MECKLENBURG COUNTY
Park and Recreation Department

MEMORANDUM

RE: Rezoning Petition #2023-164
PID# 21912104

DRAWING NO.: **RZ-01**

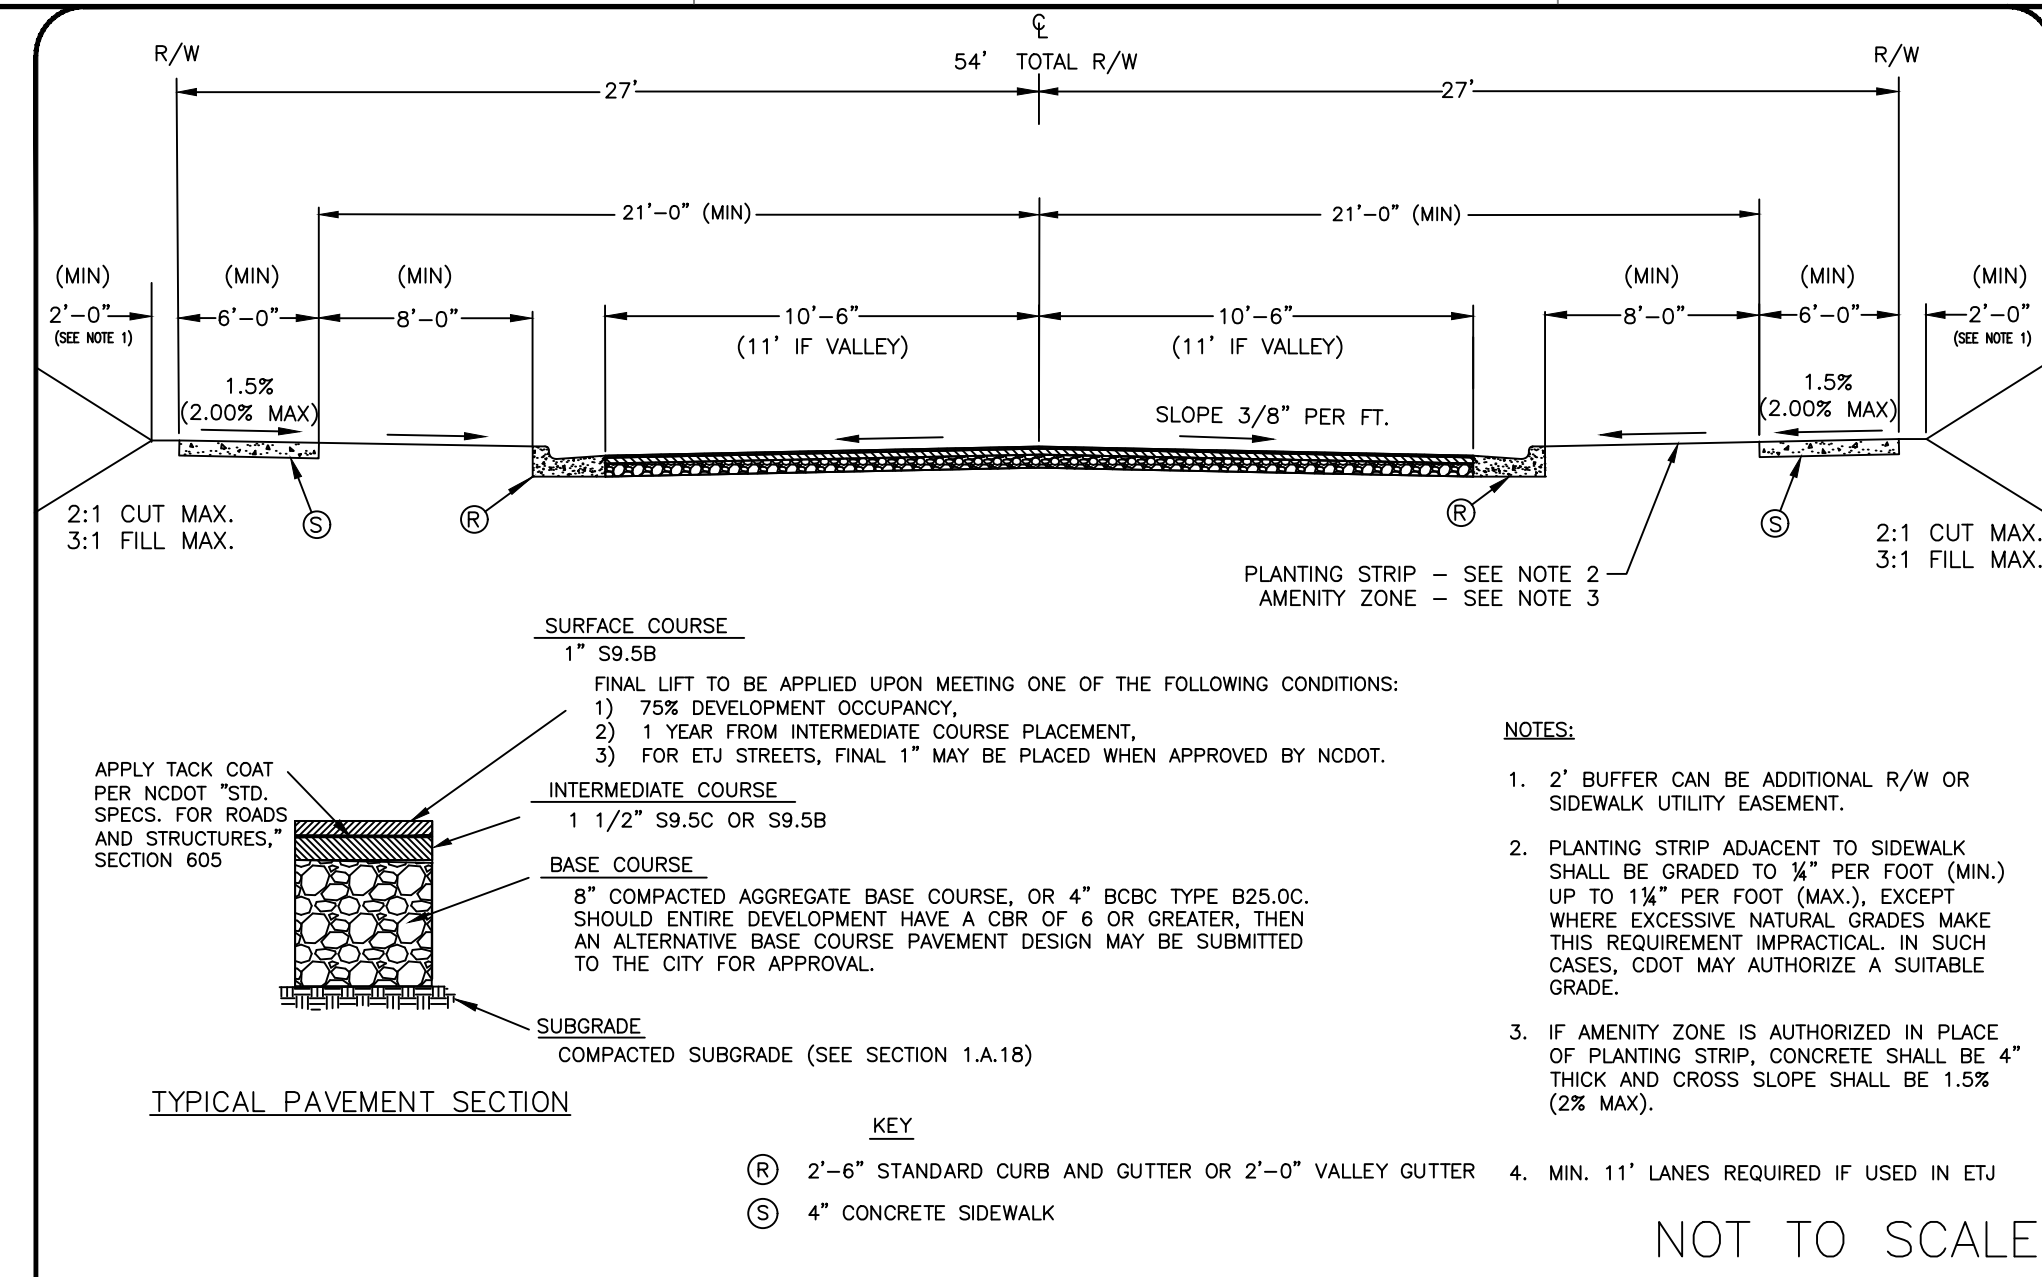
MCPR requests a bicycle and pedestrian connection between Steele Creek Road and Generations Street Park (PID 21912422). The connection can occur through publicly accessible trail development, sidewalks/multi-use paths, or a minimum of 60' wide trail easement to be dedicated and conveyed to Mecklenburg County.
